CITY OF ALBUQUERQUE

September 12, 2006

**Re: Jennifer Lin's Restaurant, Tract 13-B Black Ranch Subdivision, Grading
and Drainage Plan**
Engineer's Stamp dated 9-07-06 (B14-D13)

Hong Kong Chinese Restaurant GRADING AND DRAINAGE PLAN

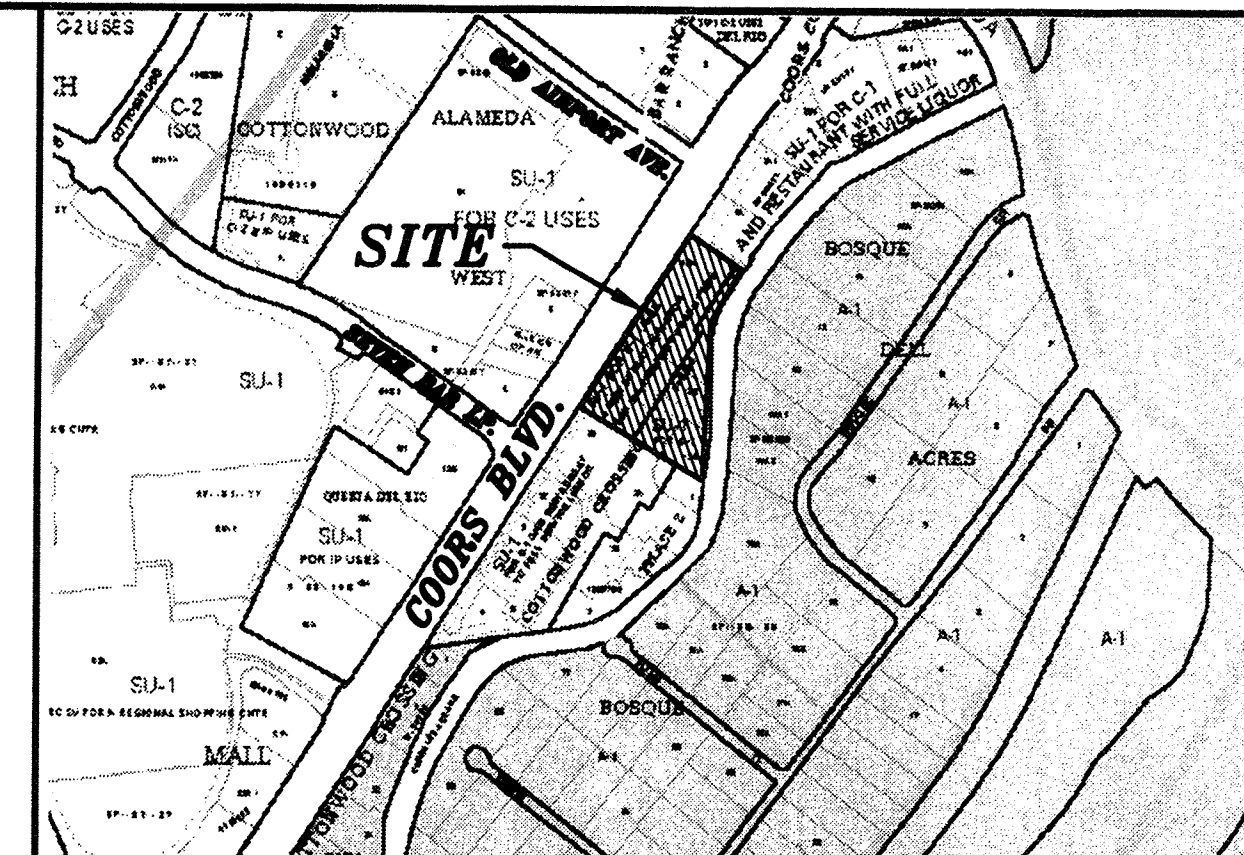
- **Per the *Development Process Manual*, all runoff generated by dumpster and compactor pads must discharge to the sanitary sewer (see Chapter 22, Section 9, Table 1). As such, details of the trash enclosures with the drains and associated spot elevations must be shown.**
- **Engineer Certification per the DPM checklist will be required.**
